Our Reference: SYD15/01513/09
(A22483413) DP&E Ref: SSD 7388 MOD 6

**ADDENDUM NO 1 TO EXHIBITION OF MODIFICATION REQUEST FOR THE RIBBON,
DARLING HARBOUR, DESIGN MODIFICATION AND EXTENSION OF CONSTRUCTION
HOURS (SSD 7388 MOD 6)
31 WHEAT ROAD, DARLING HARBOUR**

**Figure 2 Proposed roof level plan, demonstrating open roof area above pool**

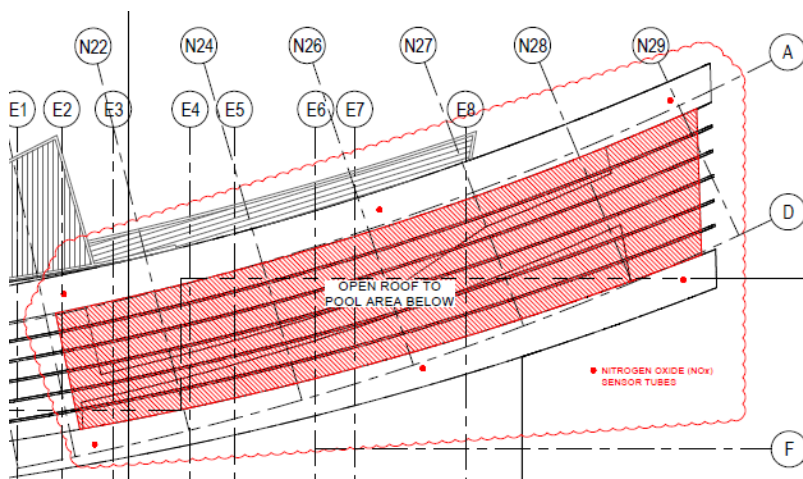
- Roads and Maritime would be very concerned with any open pool arrangement in vicinity of the stack.
- Condition B23 of the Grocon Development Consent dated 16 June 2014 issued by the Planning and Assessment Commission provides that no operable balconies, terraces or windows shall be incorporated within Grocon's building above a height of 60 metres above ground level. As the pool in question is located above 60 metres it is our submission that this proposed open pool roof design not be approved.

- Roads and Maritime is not satisfied that the persons using this development (open pool) will not be unduly affected by the CCT vent stack emissions (taking into account emergency situations such as a car fire, which would result in large amount of emission in the proposed development area in a short space of time, depending on wind and the operational circumstances.)

Given the potential risk to public health and safety to future occupants of the development, and to maintain the continuing operation of the Cross City Tunnel, Roads and Maritime recommends independent modelling to be undertaken.
